WENTWORTHVILLE PUBLIC SCHOOL

State Design Review Panel – Response to Advice Schedule

**BLOCK G - ELEVATIONS 1**

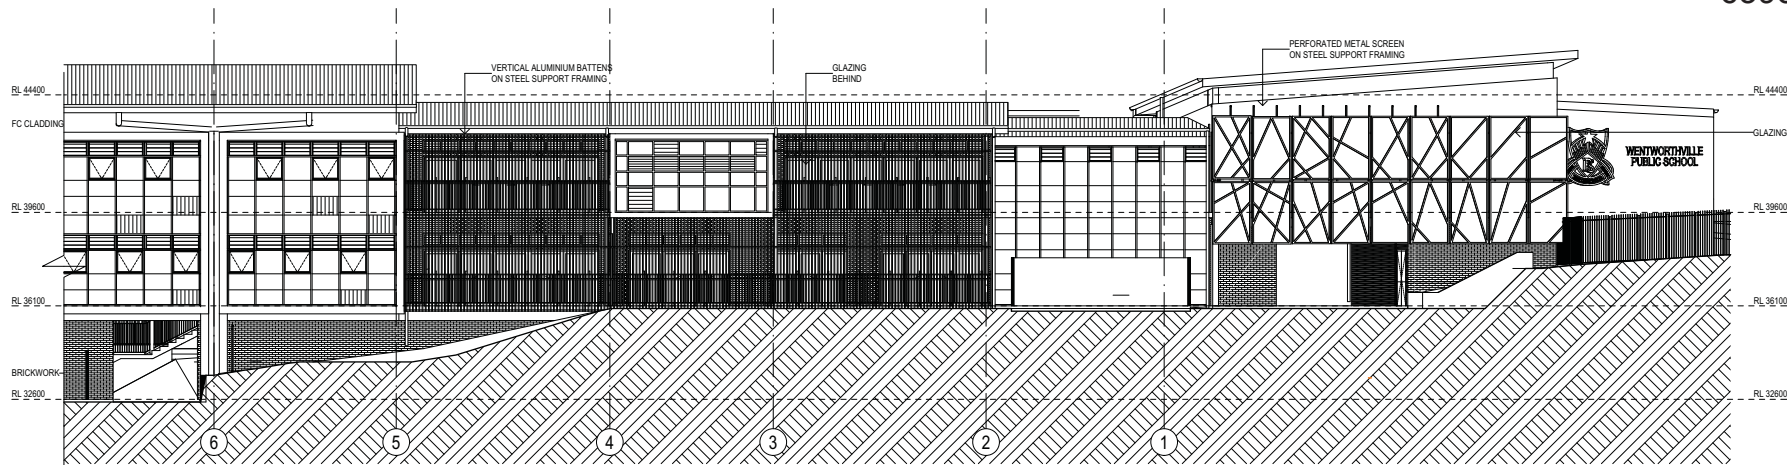
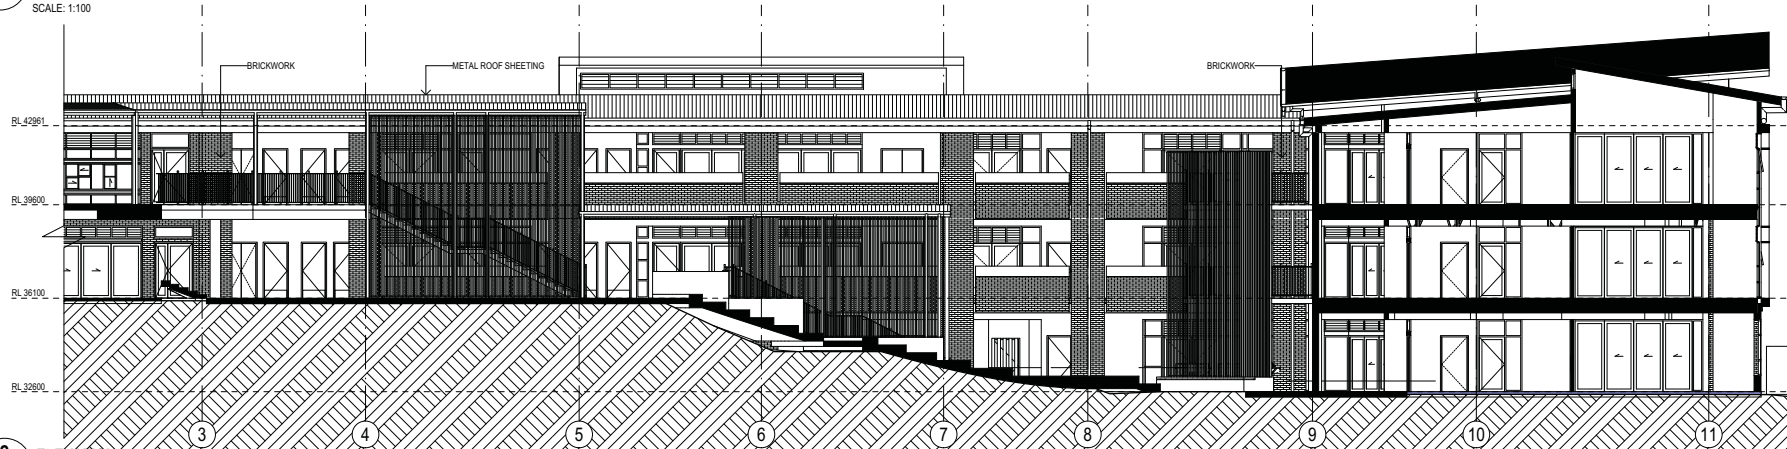
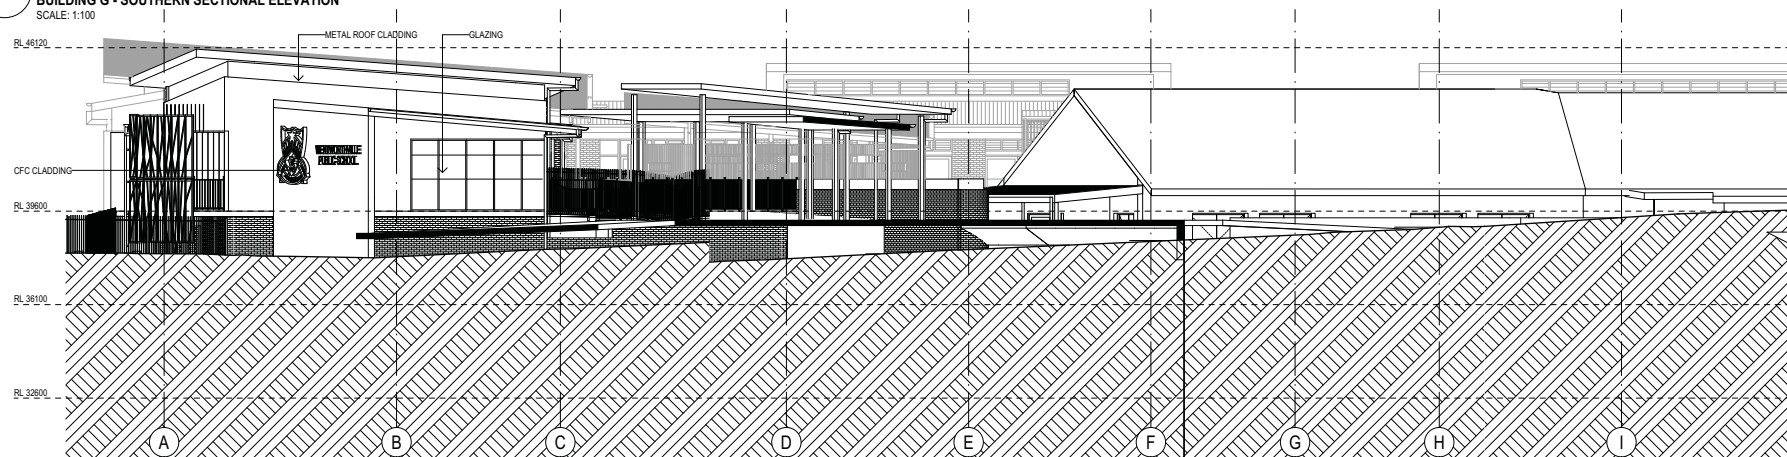
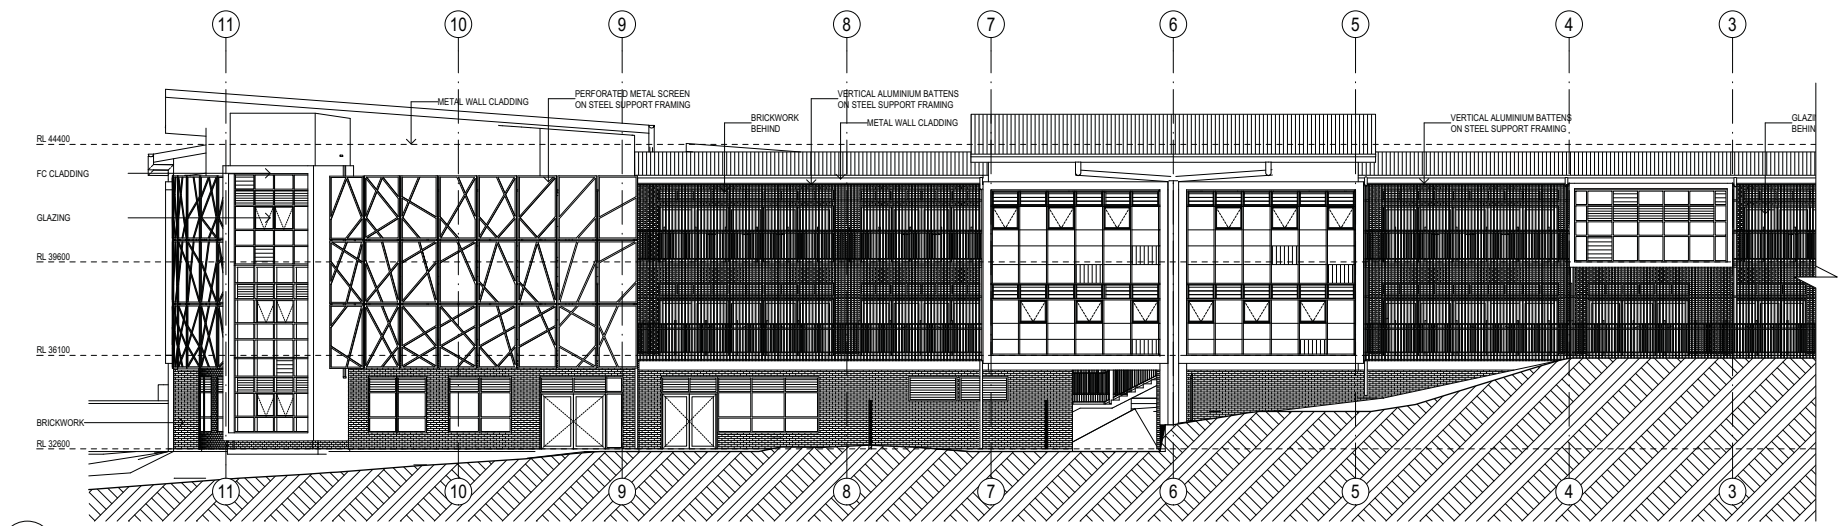
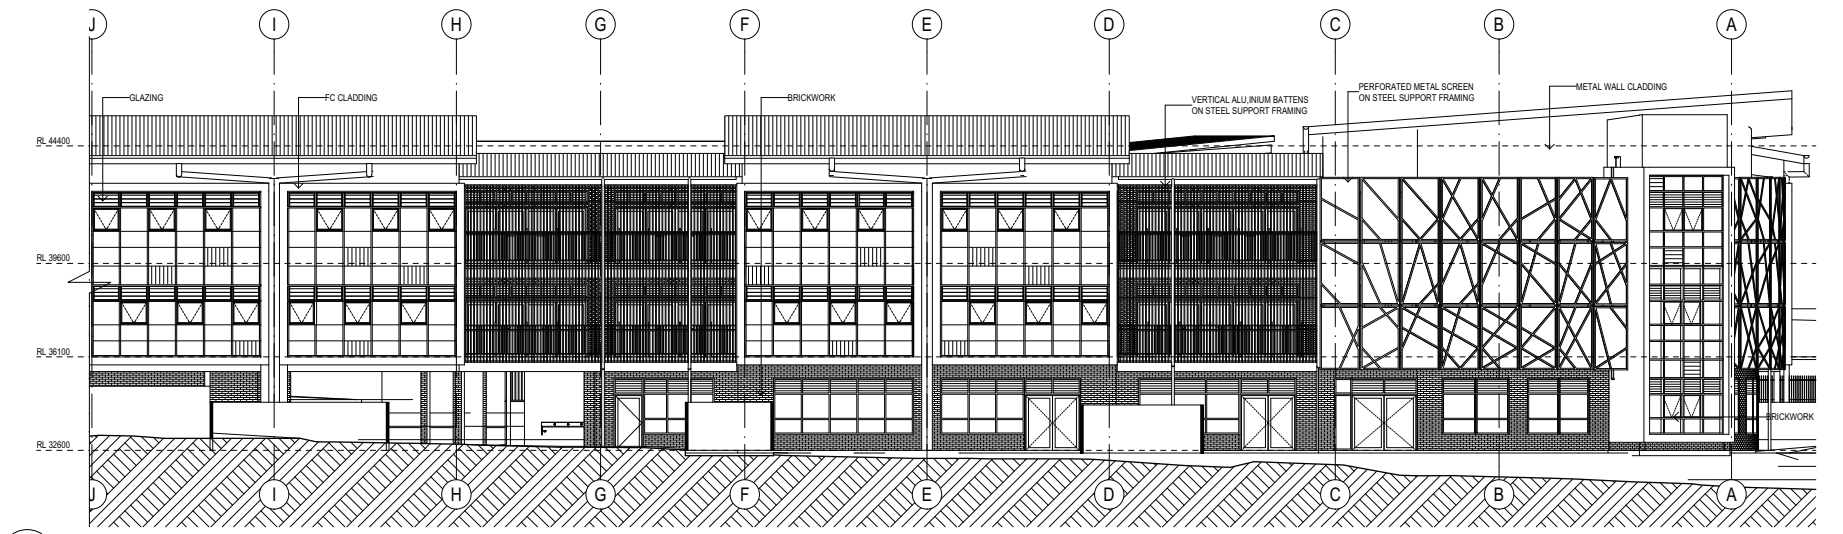
2b	<p>revising the expression of the building at the street corner (curved façade and associated roof) to be less evocative of a commercial building and more representative of a significant public building</p>	<p>The corner of Block G at the corner of Station Street and Fullagar Road presents a major opportunity to present the redeveloped school to the community. Consideration was given to making this corner element distinct from the rest of the Block G façade. The screened façade and roof overhang is consistent with the intention of addressing this important intersection in Wentworthville with a strong corner element.</p> <p>As a result, we consider the current design is appropriate.</p>
2c	<p>The design approach to the façade is generally supported, noting the intent to represent the internal planning. In this context the Panel recommends greater development of this façade strategy including:</p> <p>using clear and legible components and spacings that represent student scale elements</p>	<p>The Panel's recommendation to develop the components and spacings of the façade to represent more of a student scale has been considered. We propose to develop façade screen framing which would break the larger areas of screening down into more horizontal, smaller scale elements.</p> <p>Consideration has been given to the articulation of the façade to reduce the apparent scale. This articulation incorporates “pop out” sections to the facades and “pop up” sections to the roof to reduce the scale of the building and help generate a village-like range of elements.</p>
